# **Drax Bioenergy with Carbon Capture and Storage**

## **Change Notification**

**Document Reference Number:** 8.2.19

**Document Reference: 8.2.19 Change Notification 2 (Rev 02)**

### Proposed Changes to Land Plans for OHL1

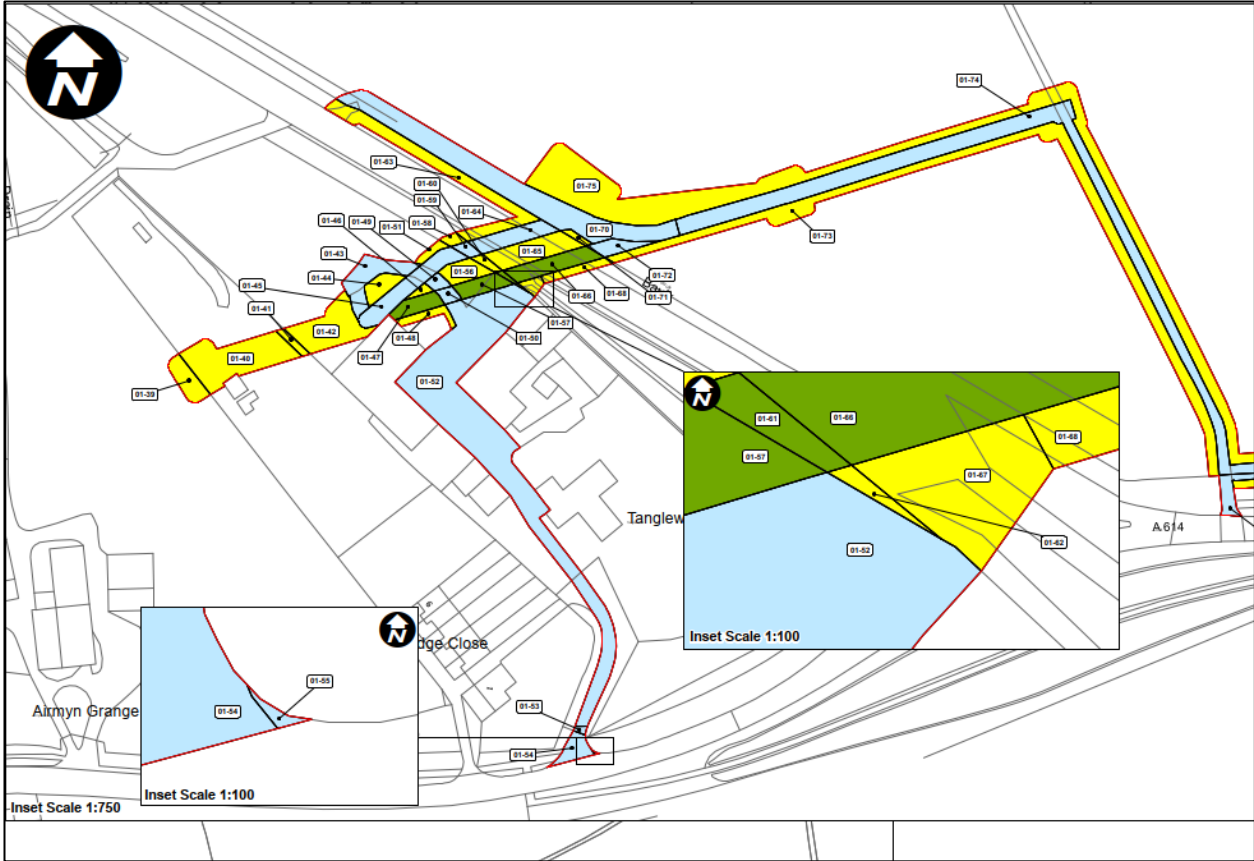
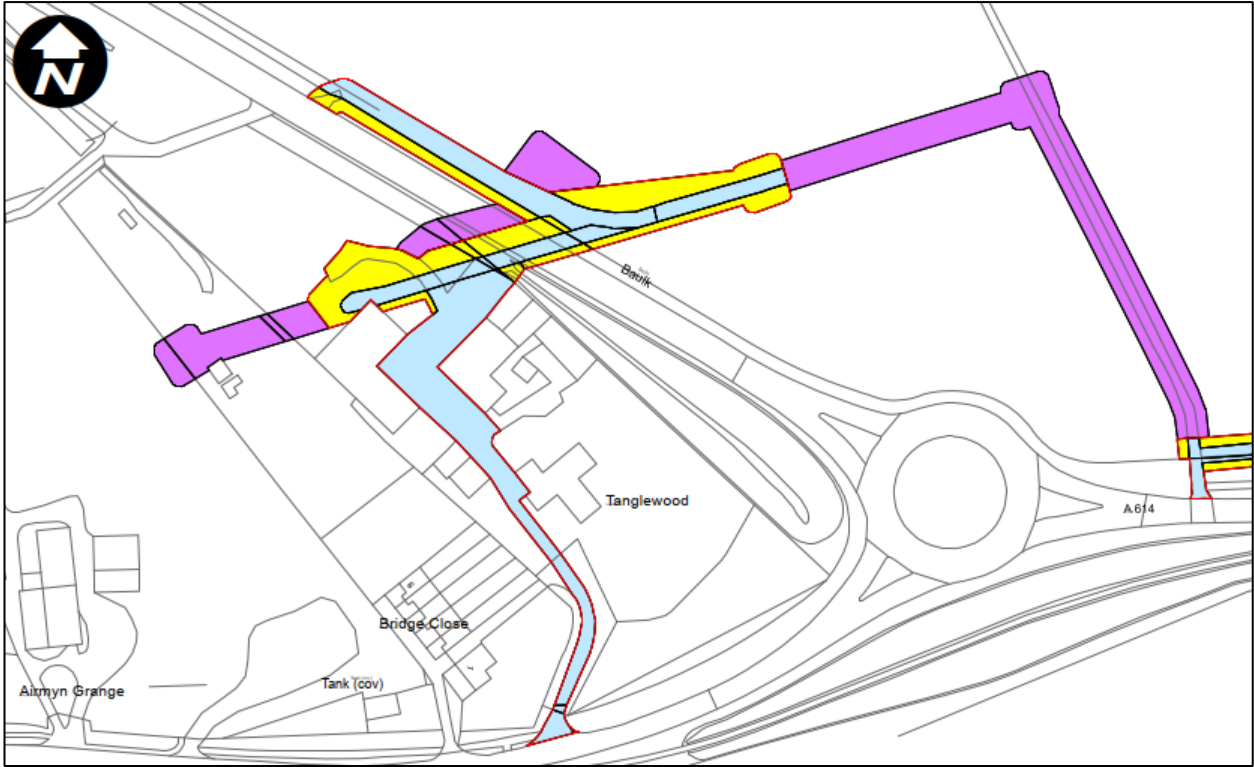
The proposed new Change Application is required to reduce the overall area of land required to enable works to overhead electricity lines (OHL1 and OHL2) and a telecommunication line (TCL1) and alter some of the rights previously sought in Proposed Change 2. Following the submission of the first Change Application, discussions have been progressed with asset owners and affected persons, which have enabled the refinement of the proposed design of works to facilitate AIL deliveries to the Site taking in to account concerns raised by affected persons and the scope of works required to relocate electrical and telecommunications infrastructure. Responses have been received from the electrical and telecommunications asset owners which confirm the nature and extent of proposed works, and the type of rights necessary to enable the proposed works to be implemented.

There are some changes in relation to proposed works to OHL1 and OHL2 where the first Change Application sought to extinguish existing rights of the electrical asset owners due to the removal of certain sections of the overhead lines and the intention of locating undergrounded replacement infrastructure in new locations. However, following discussions with the asset owners, the proposed works now include the undergrounding of electrical assets in line with their respective existing overhead alignment instead. This necessitates an 'upgrade' in the powers sought over some plots to facilitate this new routing. Following further discussion with the asset owners, it should be noted that this affects slightly more land than was discussed at the Hearings.

## Proposed Changes to Land Plans for TCL1

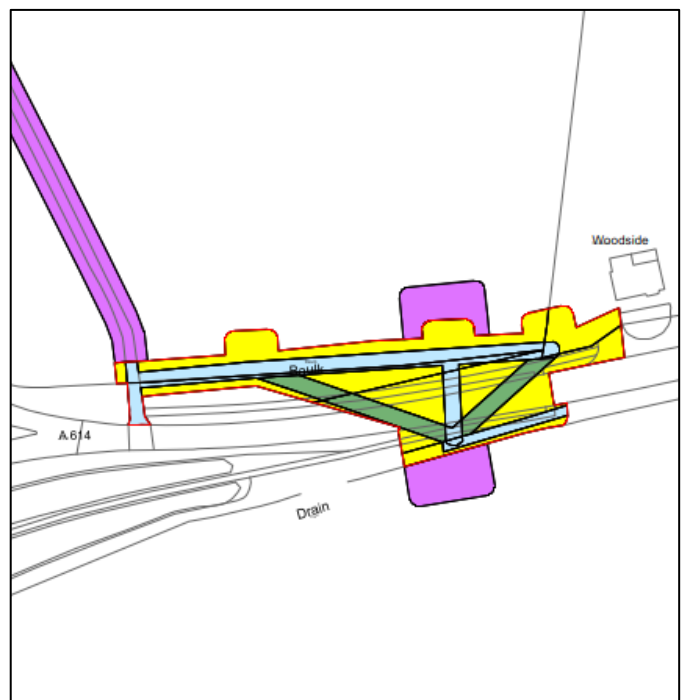
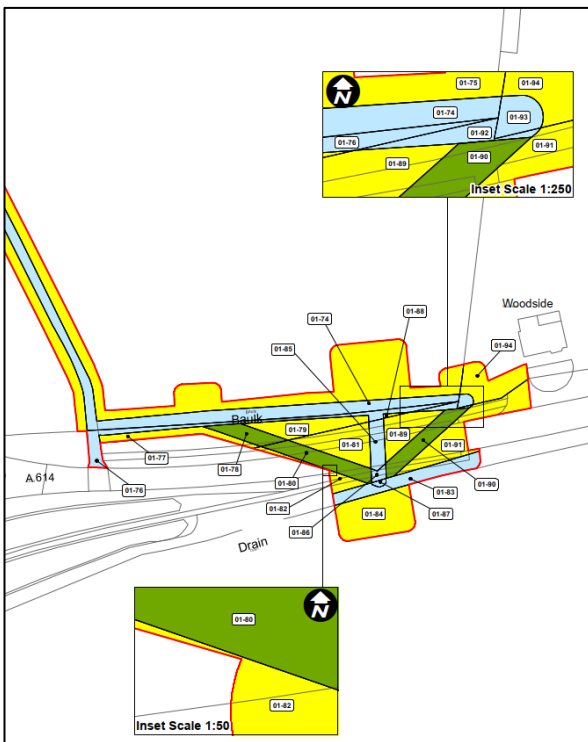
In respect of TCL1, the asset owner has indicated that undergrounding is not required, and instead the existing assets could be made taller, to remove the conflict with the AIL movements for the Scheme. This has enabled a reduction in construction land requirements for these works.
